## Building

## Energy

① M - HRV LEVEL 1  
3/16" = 1'-0"

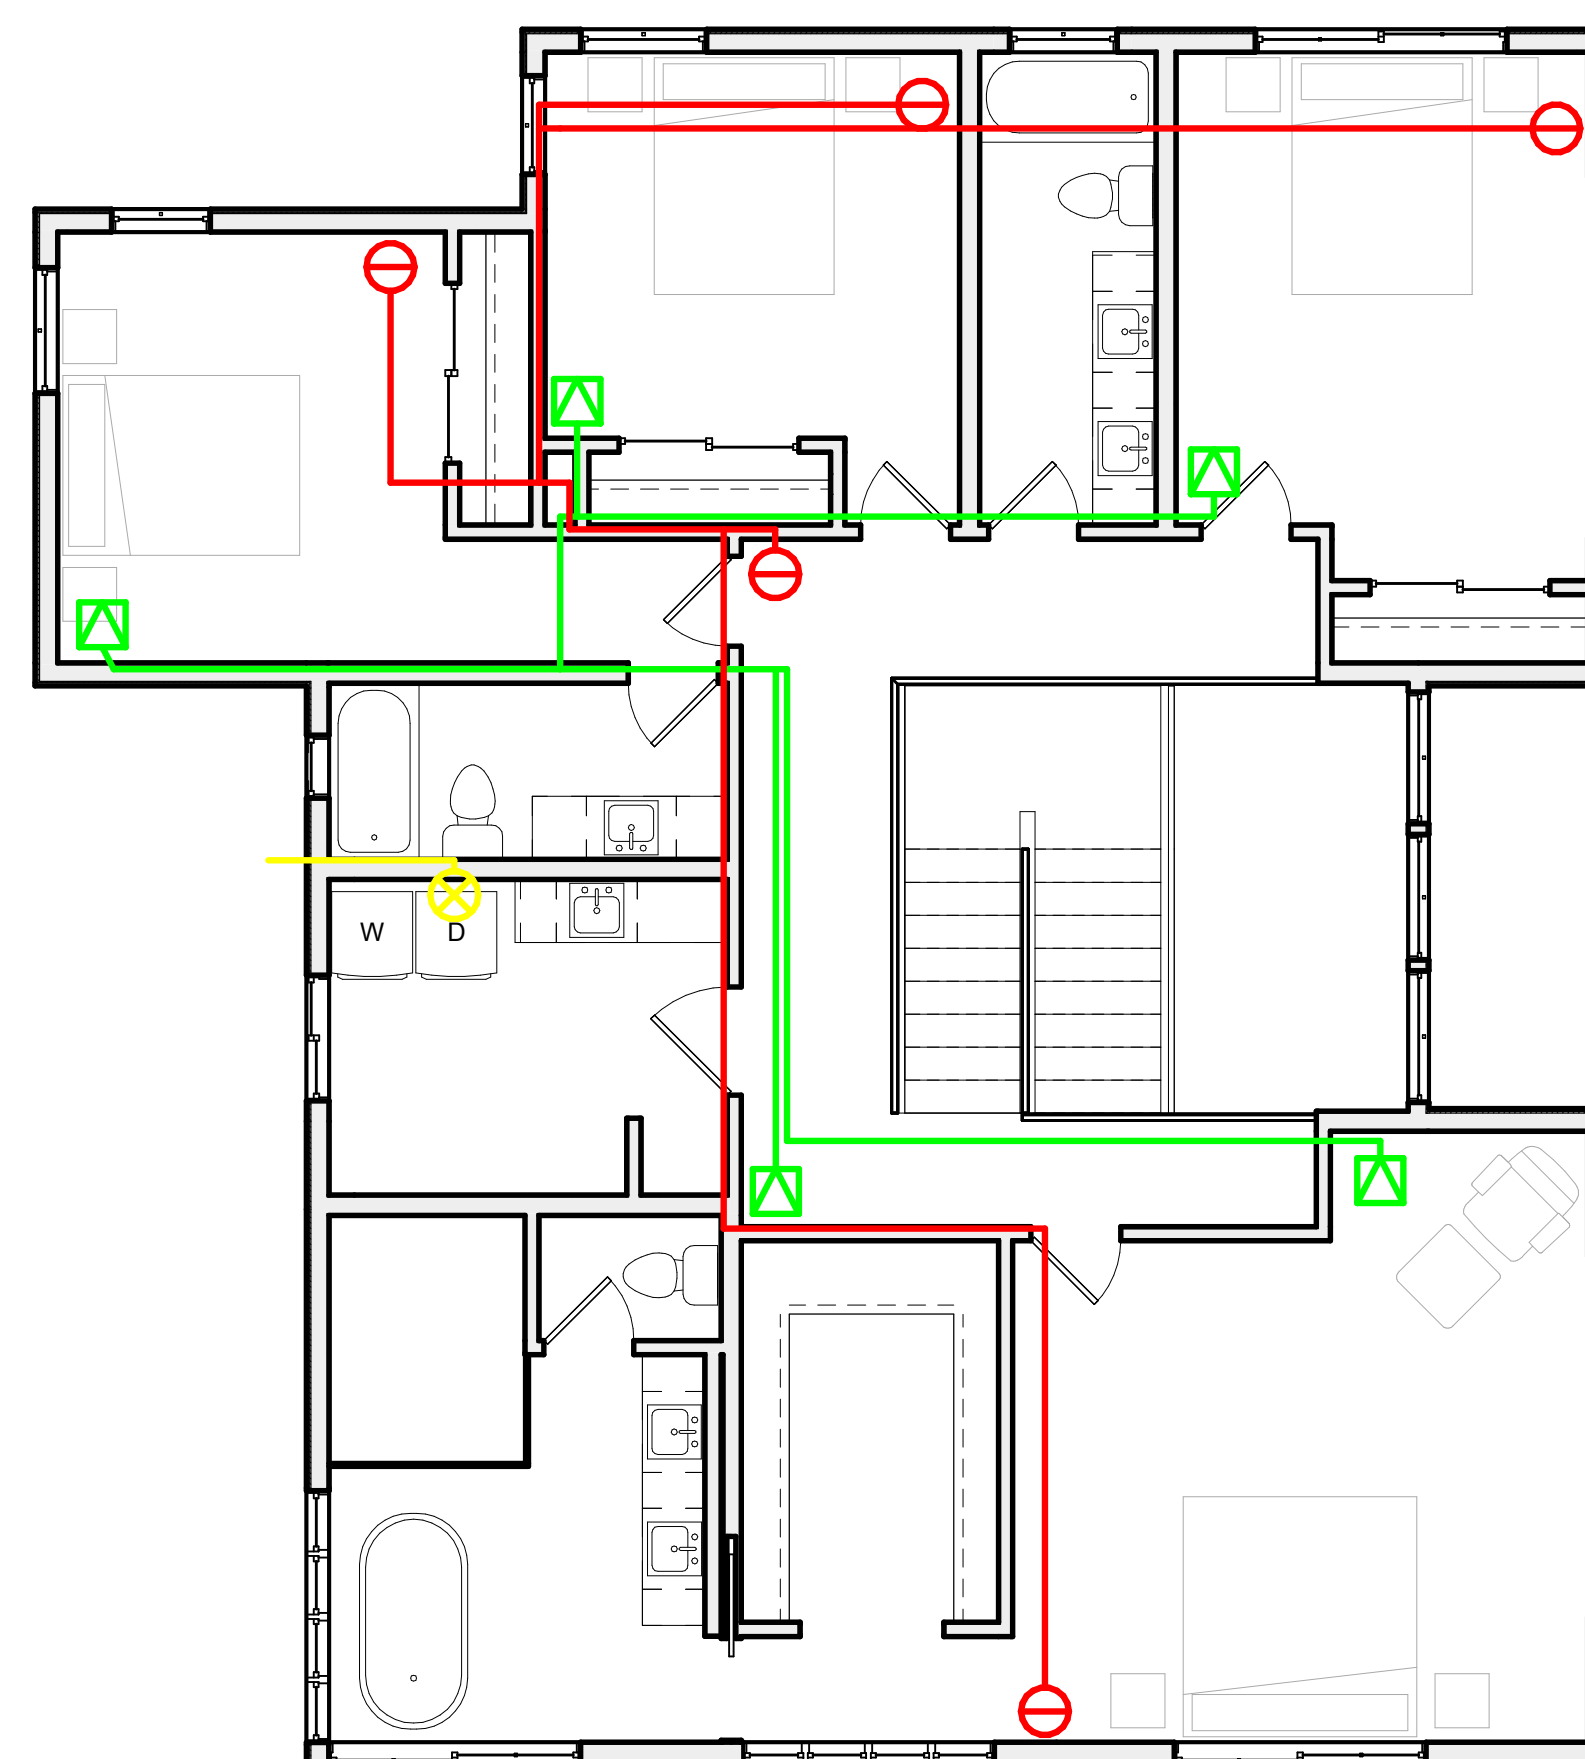
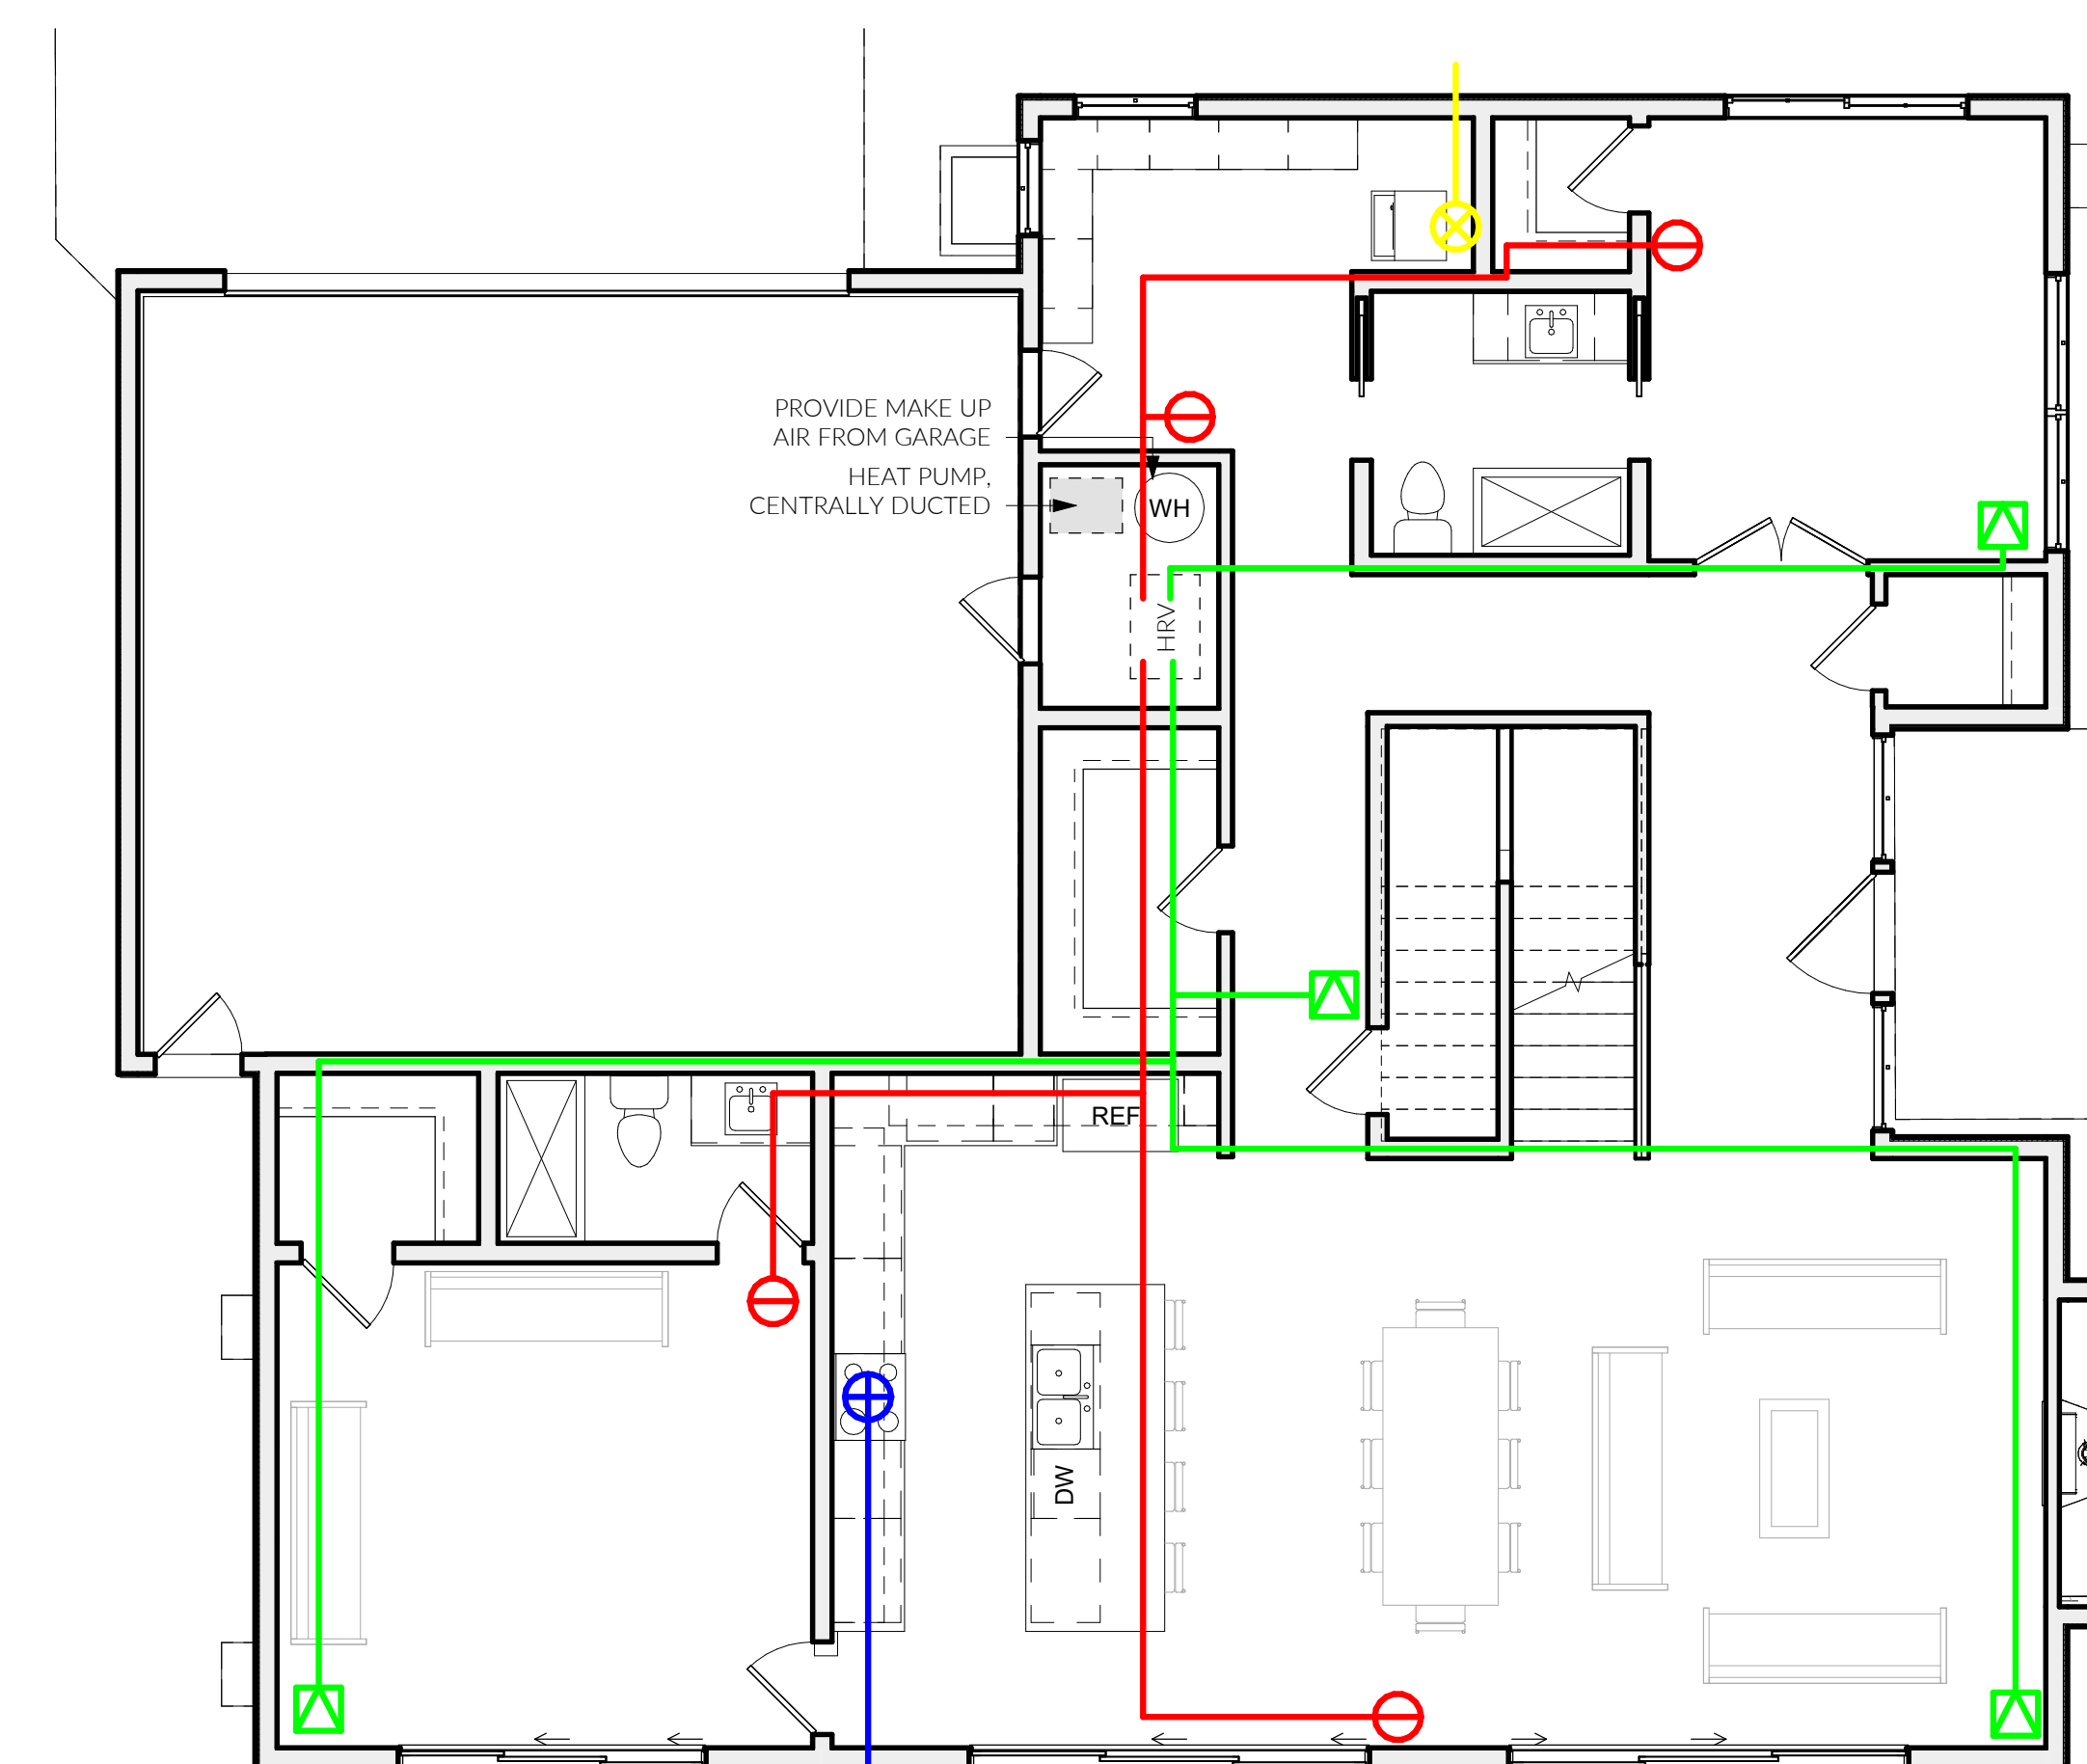
- a. *Gross heated and glazing areas updated.*
- 3.) The location of all interior and exterior mechanical equipment must be clearly indicated on the drawings. It is unclear where the heat pump is to be located.

- 8.) Indicate which whole-house mechanical ventilation system is being provided to comply with the requirement in IRC M1505.4. The Mercer Island Cover Sheet refers to Sheet M1.0...
  - a. *Sheet M1.0 included showing HRV details satisfying whole house mechanical ventilation requirements.*

- 9.) Clarify the mechanical ventilation rate in accordance with IRC M1505.4.3. The minimum whole-house ventilation rate from IRC M1505.4.3(1) must be adjusted by the system coefficient...
  - a. *Please see note 5 on sheet M1.0.*

- 11.) Provide notes on the drawings to address whole-house mechanical ventilation system controls to show compliance with the requirements in IRC M1505.4.2.
  - a. *Please see note 8 on sheet M1.0.*

- a. *Mechanical equipment shown on sheet M1.0.*
- 4.) Energy Credit Option 2.3 has been selected per WSEC Table R406.3 for Air Leakage Control and Efficient Ventilation. This requires the tested air leakage rate in WSEC 402.4.1.2 to be reduced...
